Consultation Response from KC, Highways Development Management (HDM)

2024/91242 Land north east of Shepley Road, Stocksmoor, Huddersfield, HD4 6XW

Erection of residential development (up to 50 dwellings) with associated access, parking, public open space, landscaping and infrastructure

Date Responded: 14/10/24 | Responding Officer: A.Darwin | Responding Ref: 12-33/18

Drawing No. AMA-20547-ATR006-2.4 Rev. P01

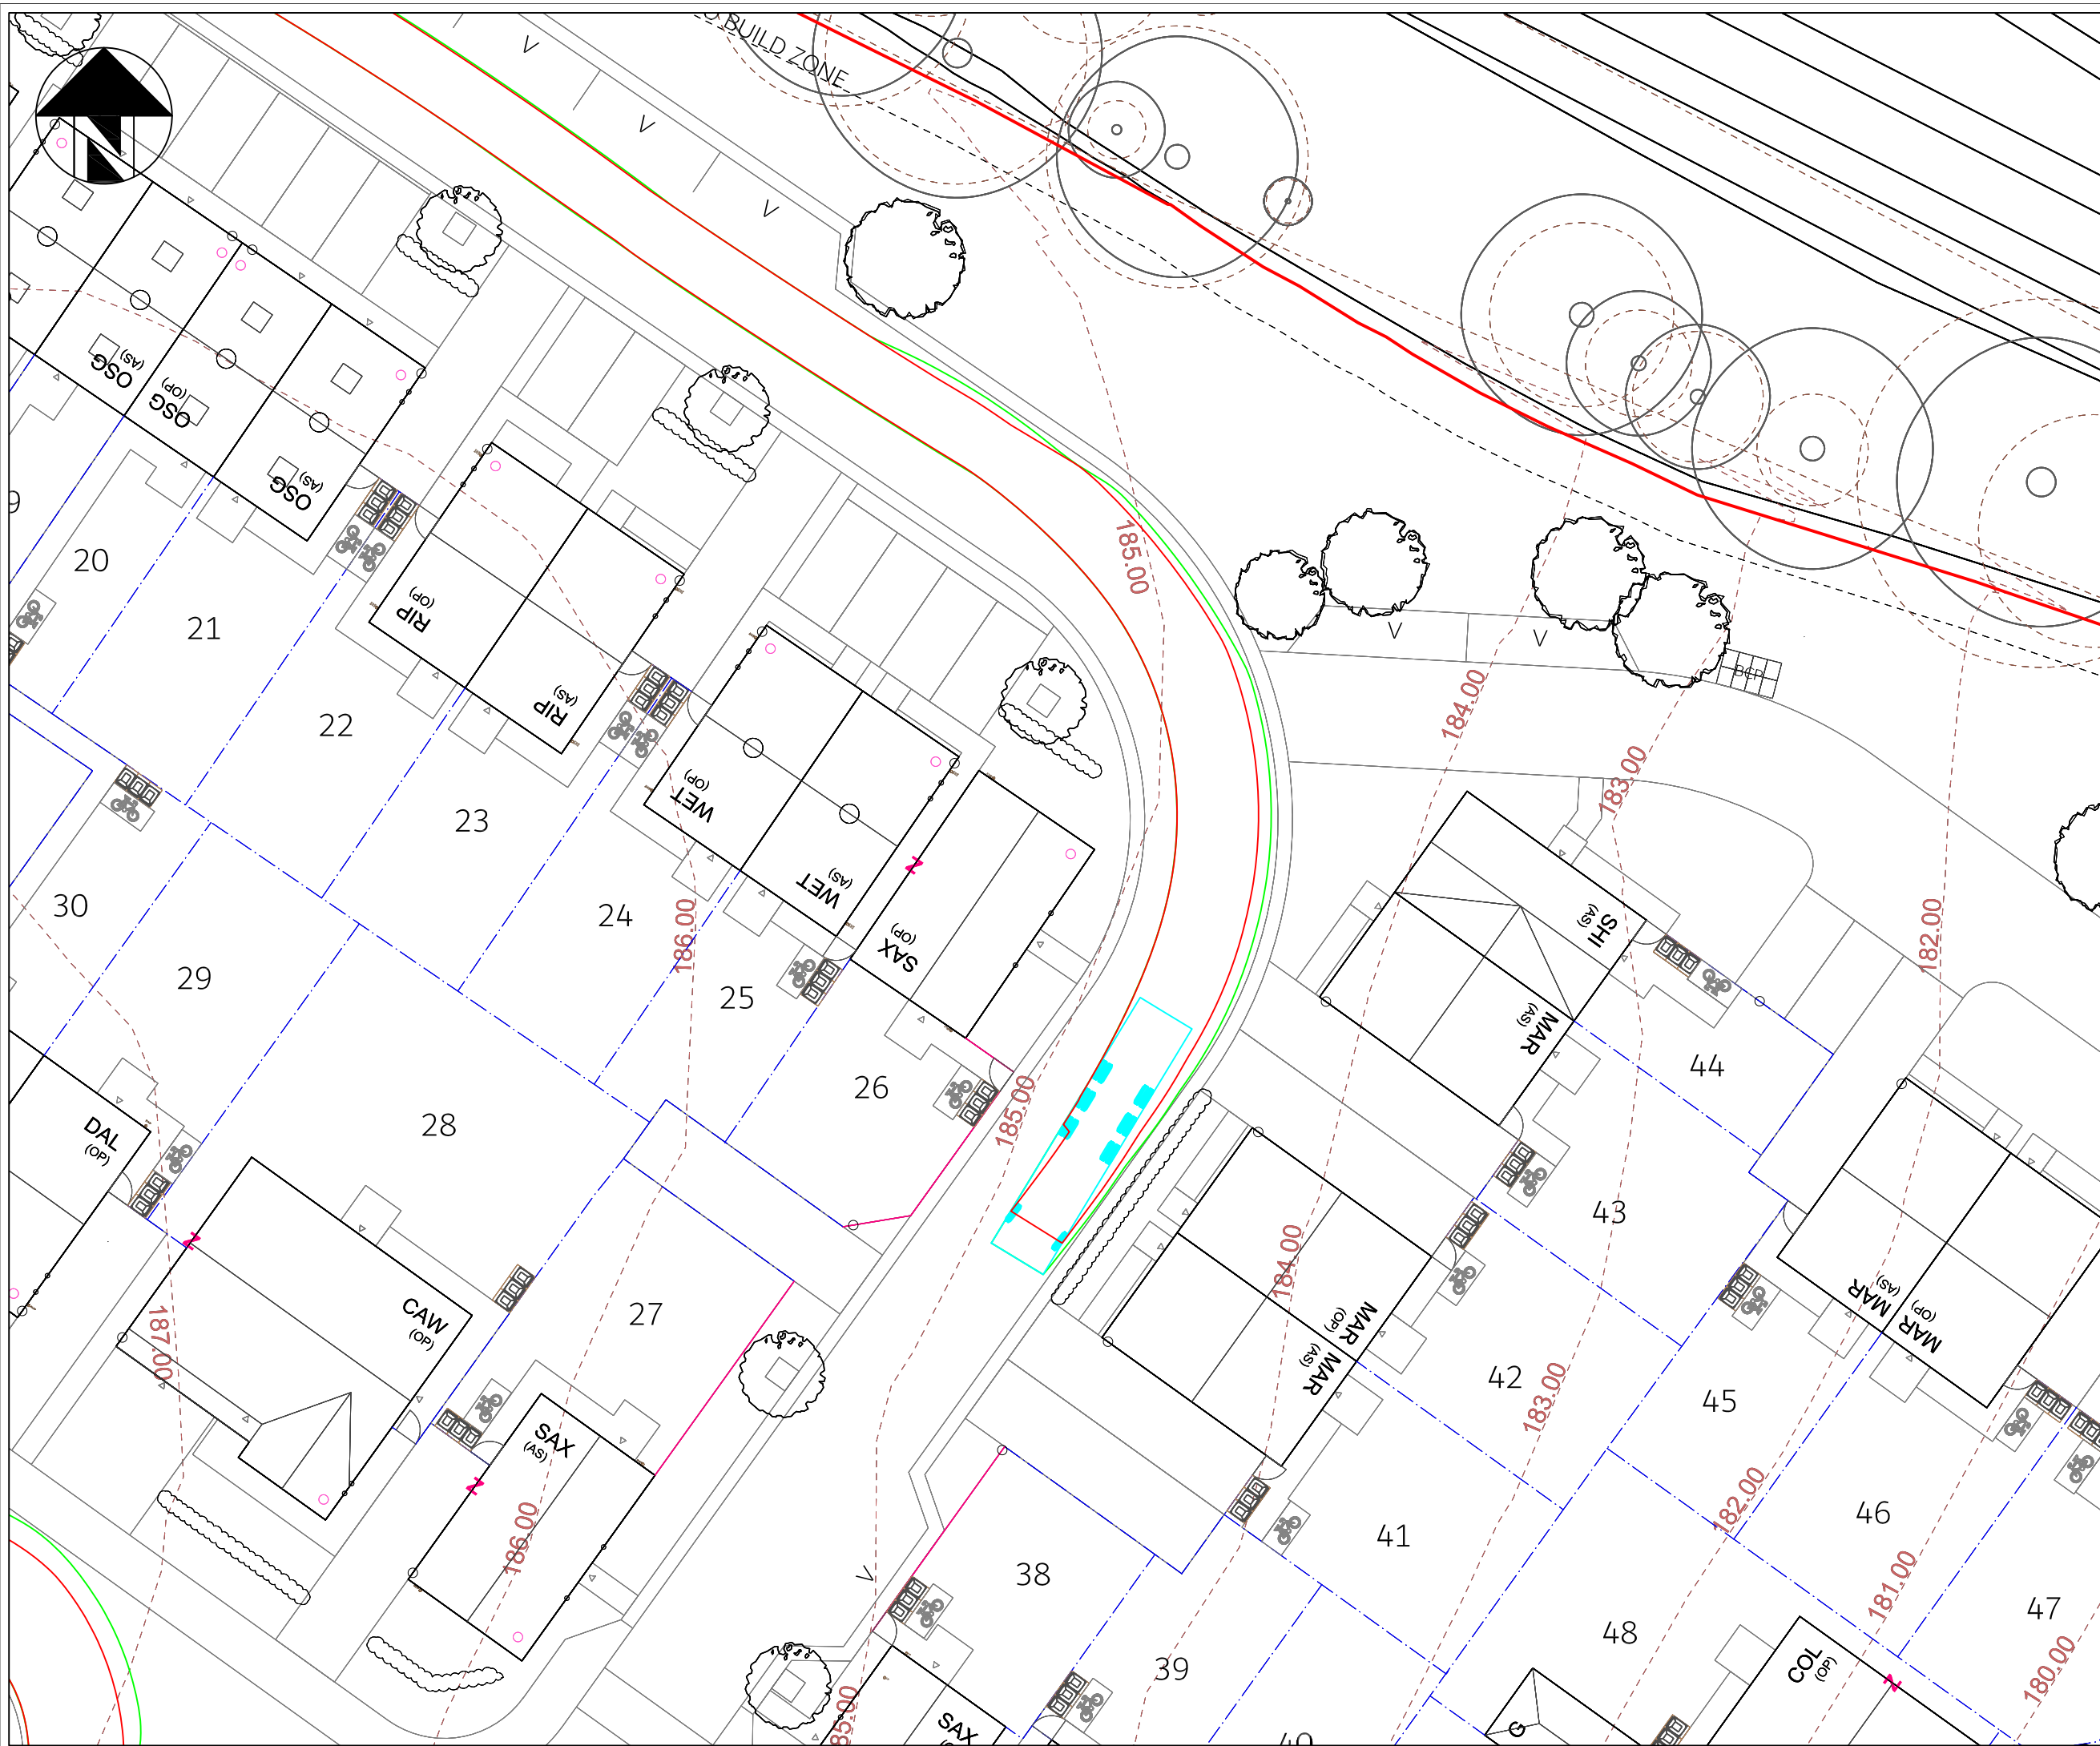
- Additional swept path analysis is required to confirm that a large vehicle (e.g. refuse vehicle) can pass a light vehicle on the widened bend (e.g. passing a stationary car waiting to turn right into the access). This may result in some additional carriageway widening being necessary (in addition to the widening to 6m as currently proposed). It is noted that Shepley Road is signed as being unsuitable for heavy vehicles. As such, passing by large vehicles will be infrequent and only a minimum level of clearance (e.g. 250-500mm) is expected to be demonstrated by this additional swept path analysis.

- To enable highway adoption, swept path analysis is required to demonstrate that a 11.85m refuse vehicle can pass an oncoming or parked family car throughout the layout, which is likely to require bend widening to accommodate these manoeuvres. This has not currently been demonstrated.

- The proposed turning head at the end of the shared surface street appears to have been checked with swept path analysis using stationary steering, which is not acceptable. Therefore, this needs to be rechecked without the use of stationary steering, which is likely to require the turning head to be enlarged (typically turning heads need to be circa 30m long to accommodate the Councils design refuse vehicle).
